8 June 2011

M5 West Widening Project- Submission on the Preferred Project Report

Attachment A

Issues and Concerns

M5W - proposed noise barriers - sheet 1
May 2011

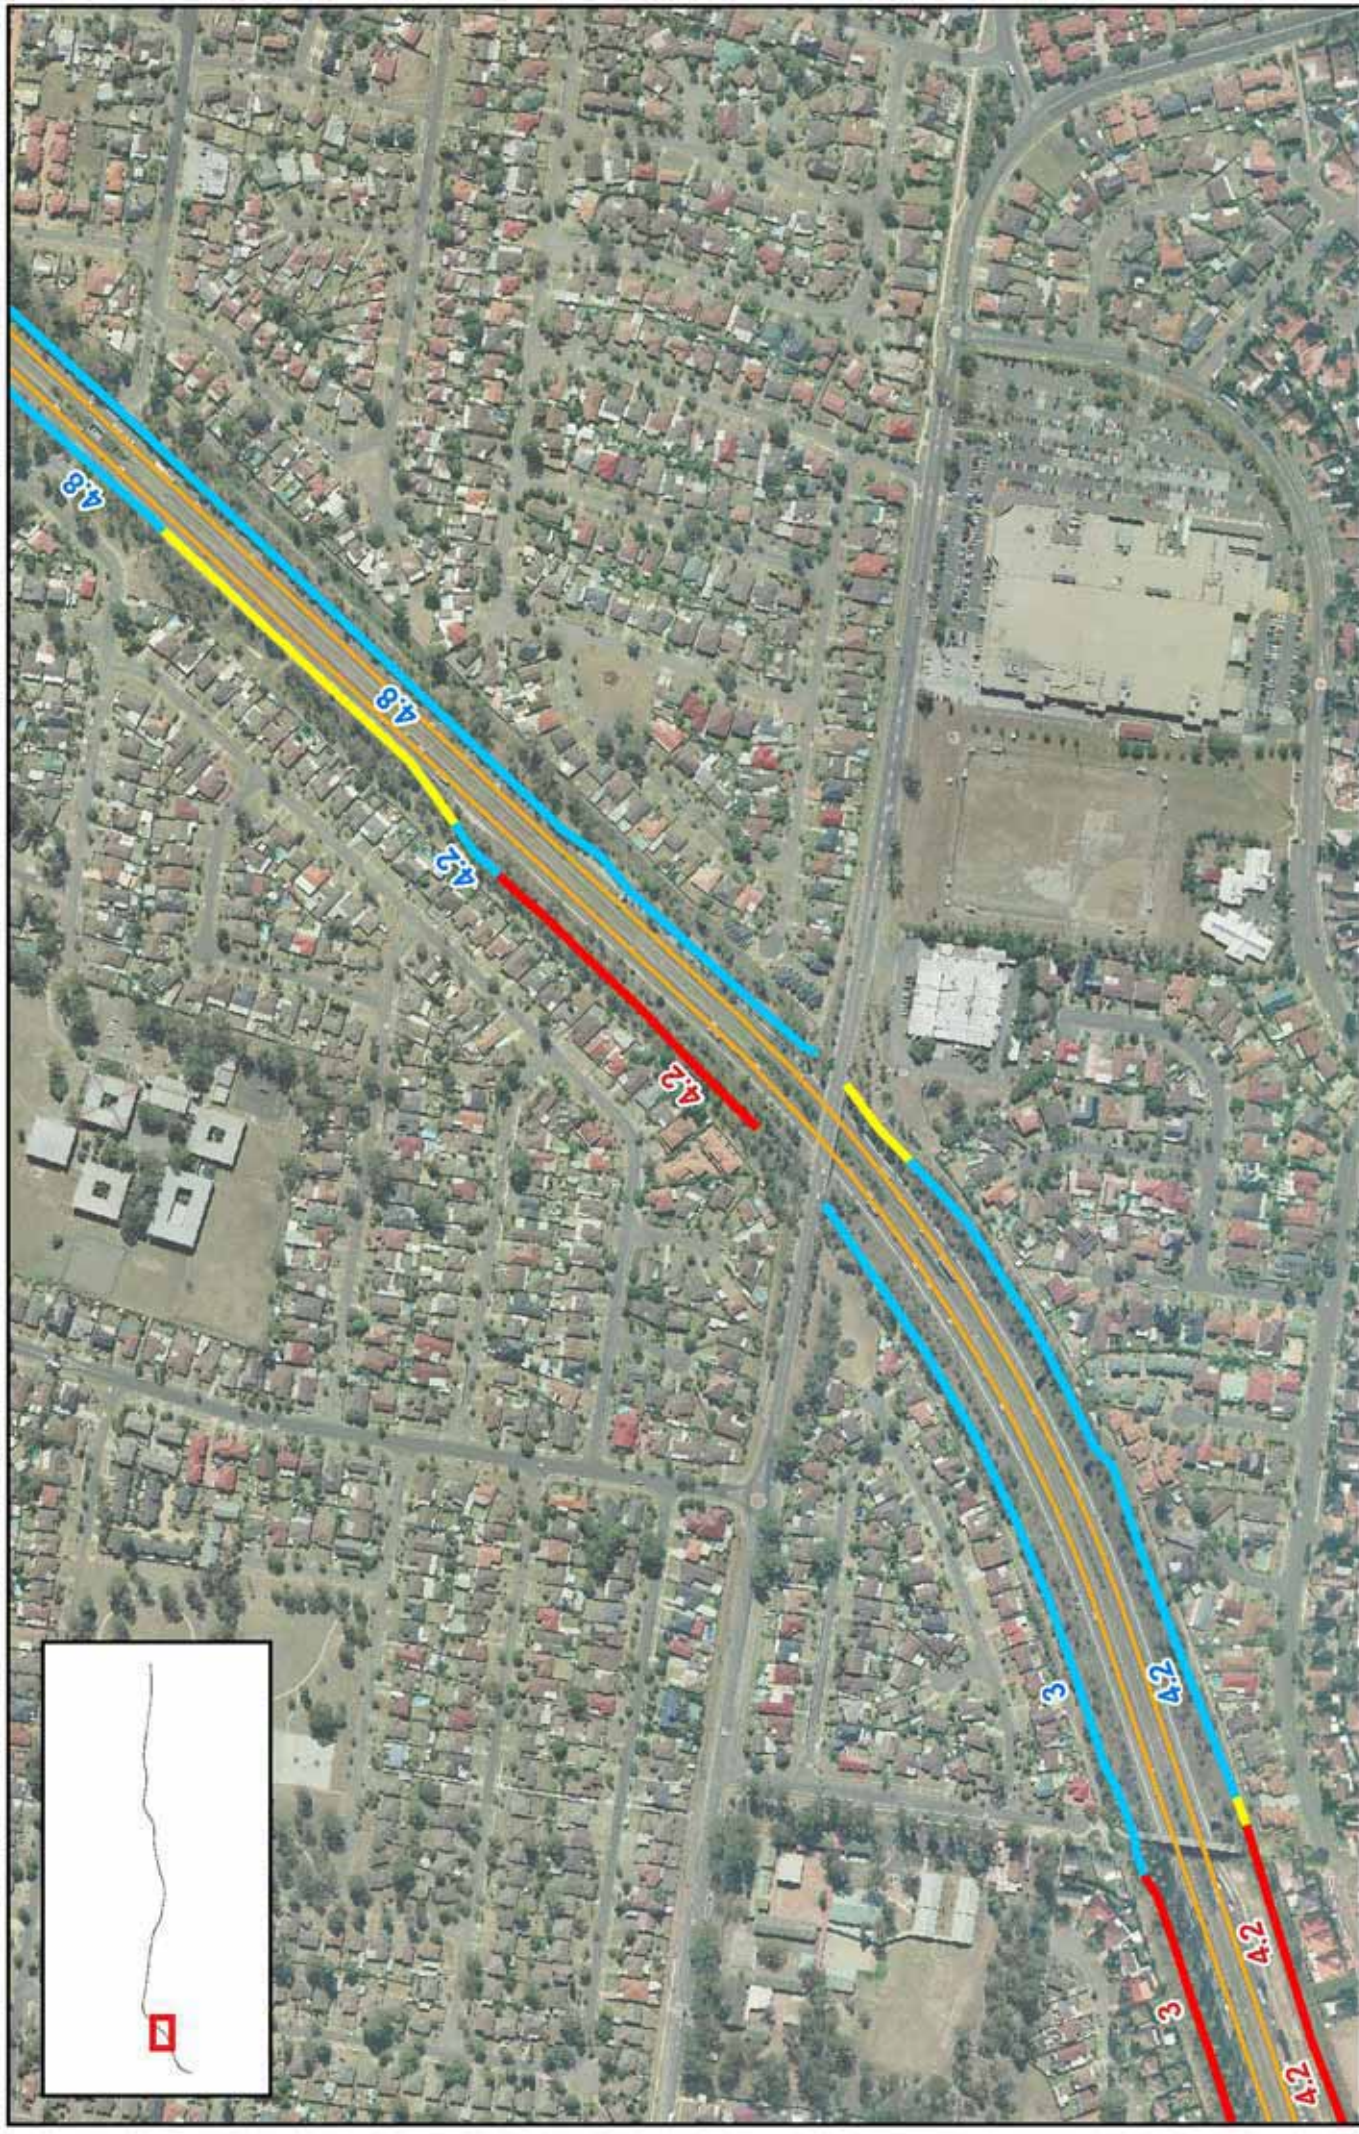
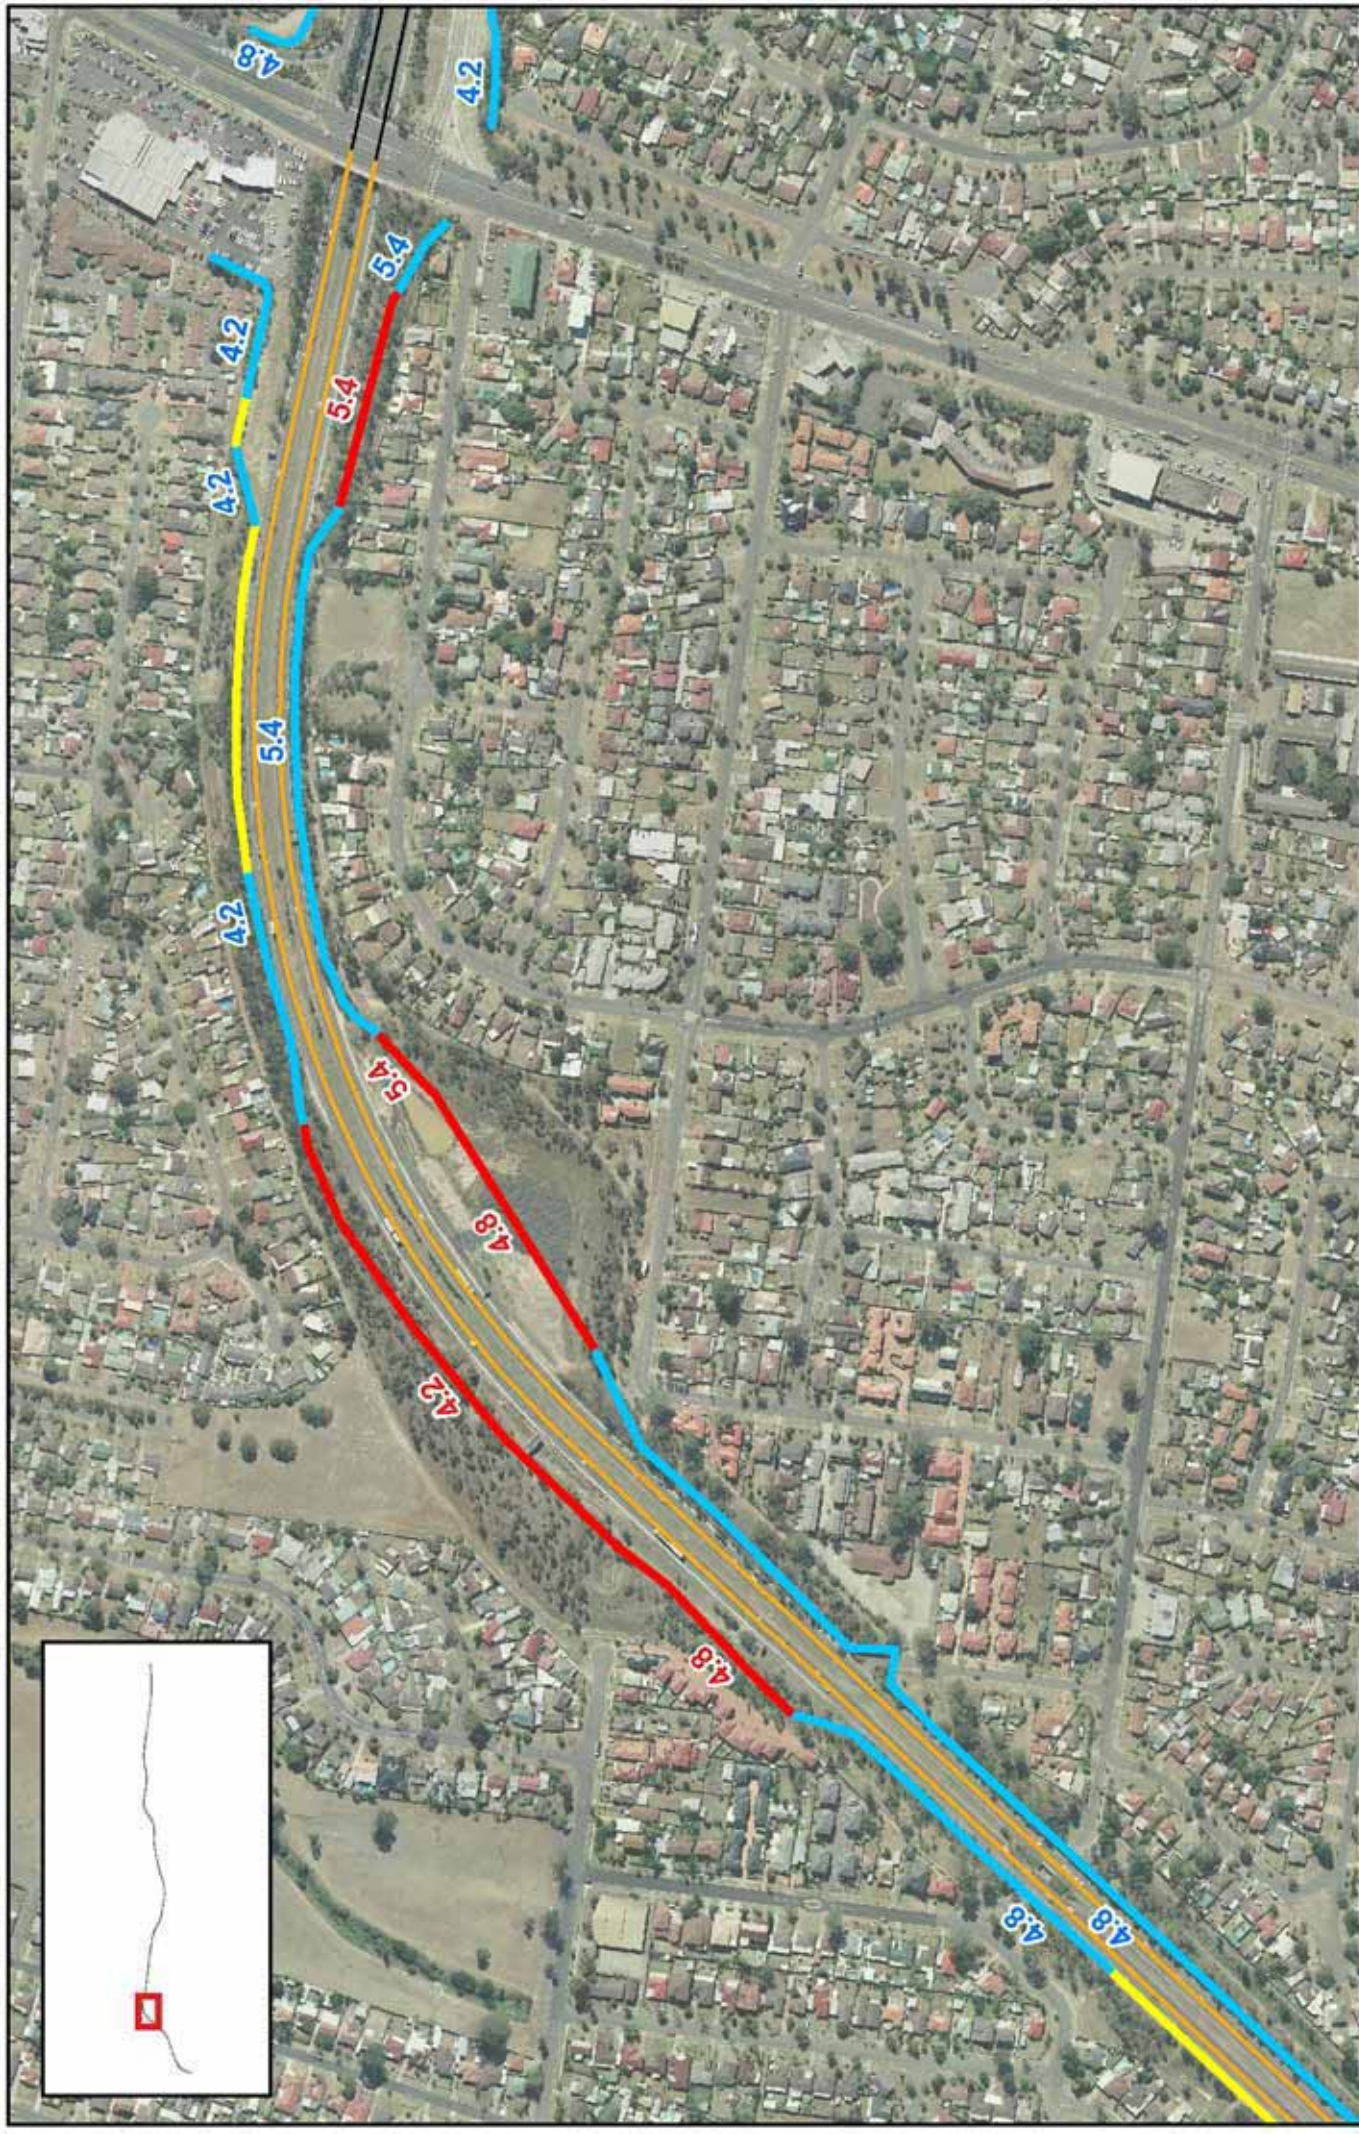
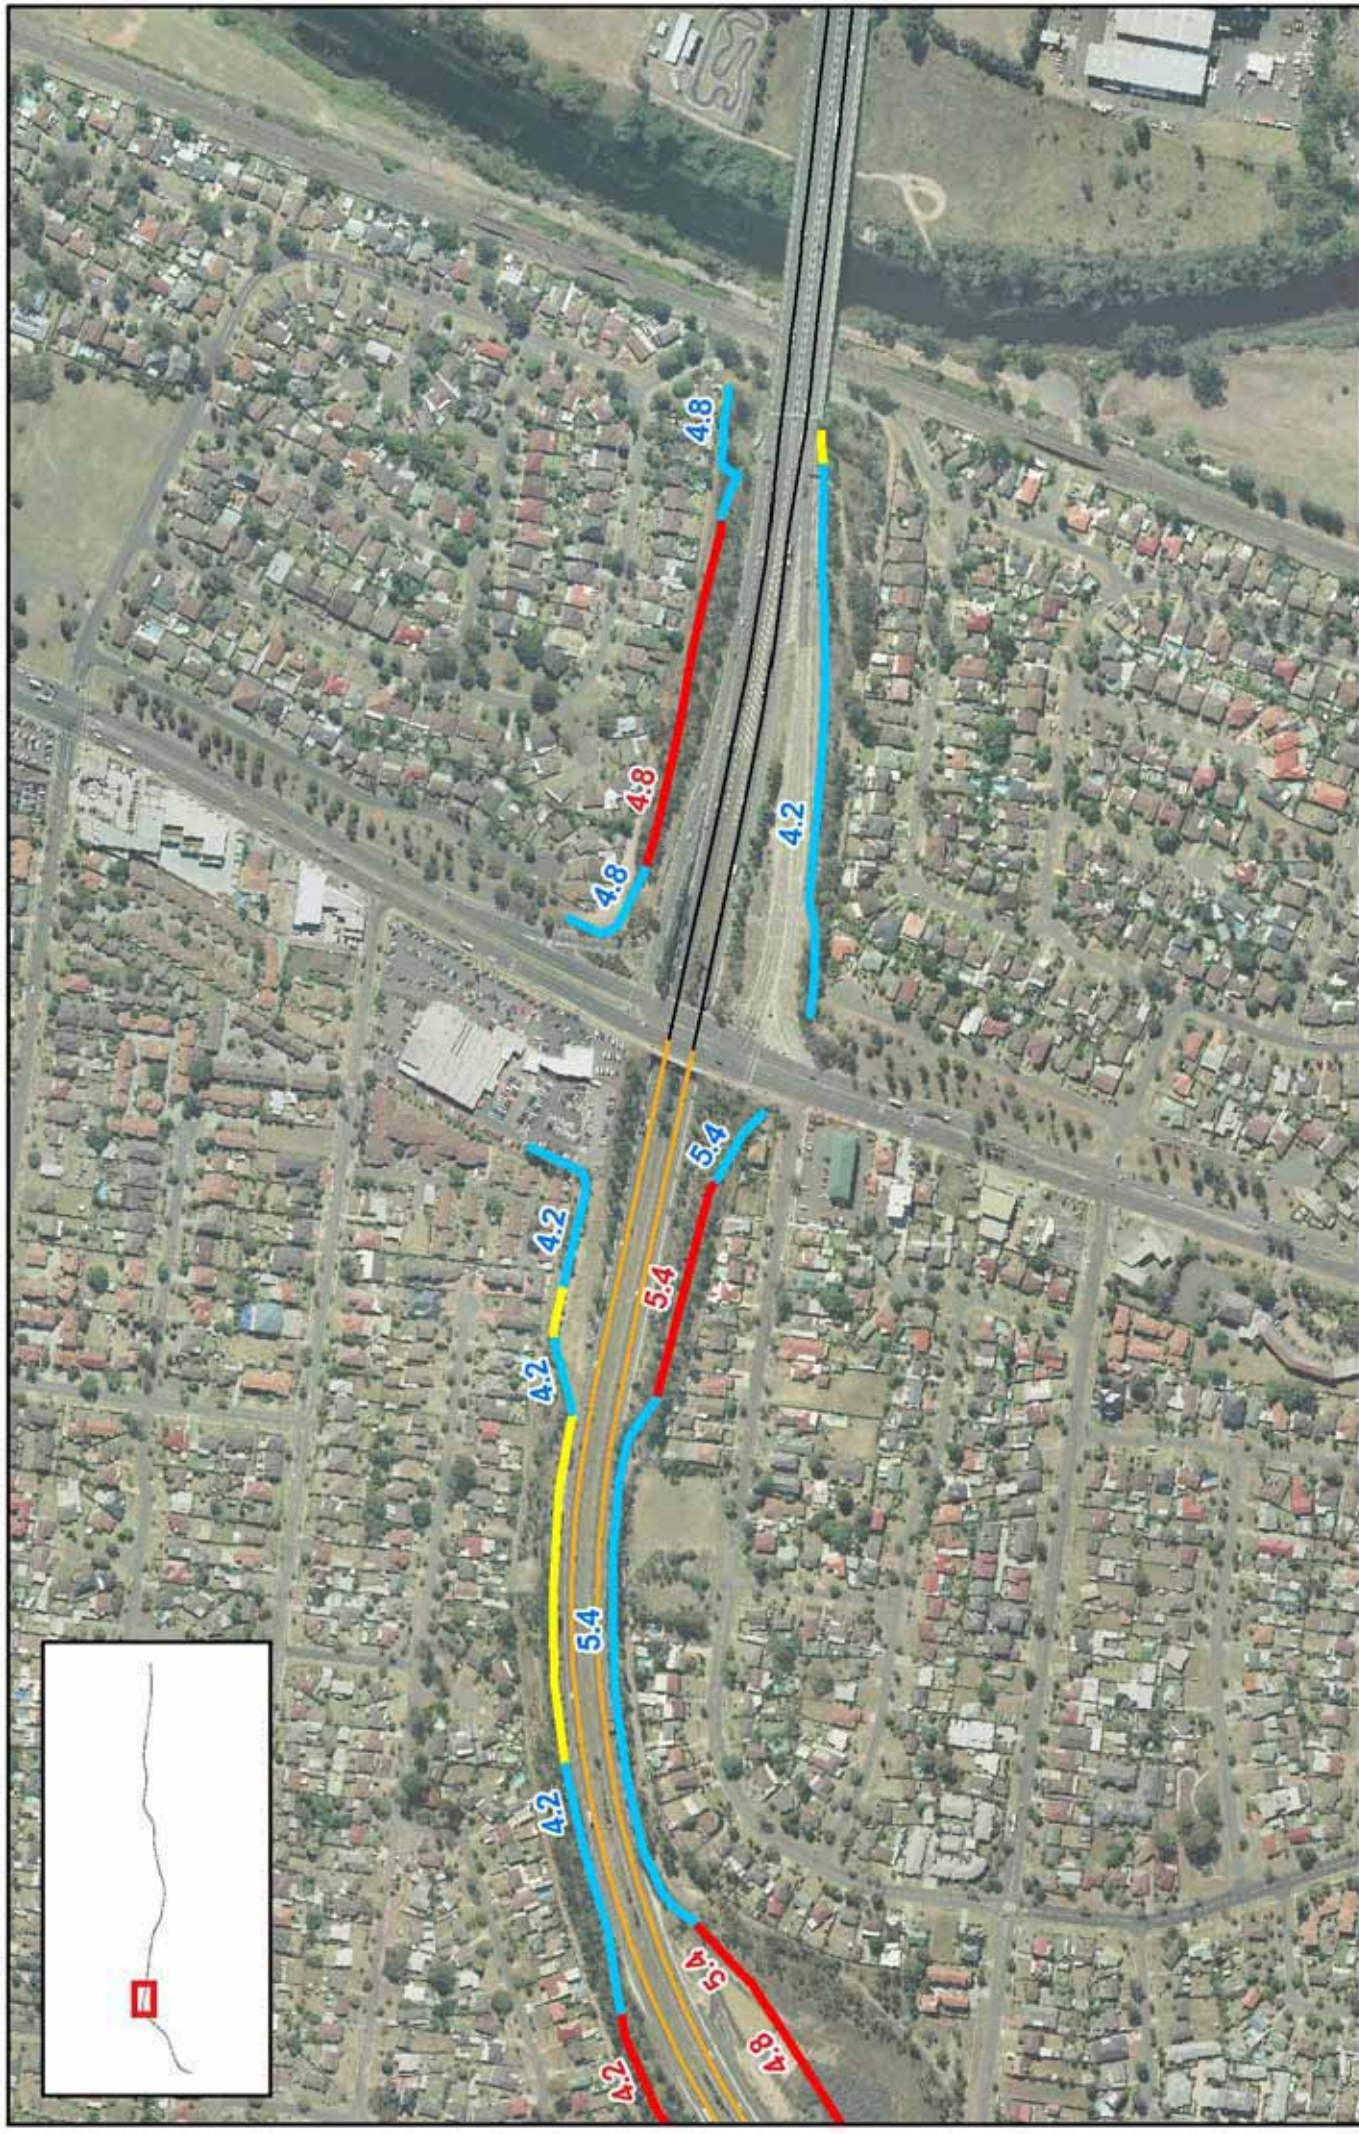
Council is concerned that the new changes to the noise barriers and installation of architectural treatments will have a negative impact on the amenity of the residents, such as limiting solar access into a dwelling and glare problems during the night which have not been discussed in the Environmental Assessment and/or the Preferred Project Report.

The Preferred Project Report currently does not specify noise mitigation details for reducing noise impacts on sensitive land uses where noise criteria are exceeded.

The 'Revised Statement of Commitments' must include the following statement: "Bankstown City Council and all affected properties within the study area will be consulted prior to the commencement of the project to discuss and develop an Operational Noise Management Plan to mitigate the noise impacts."
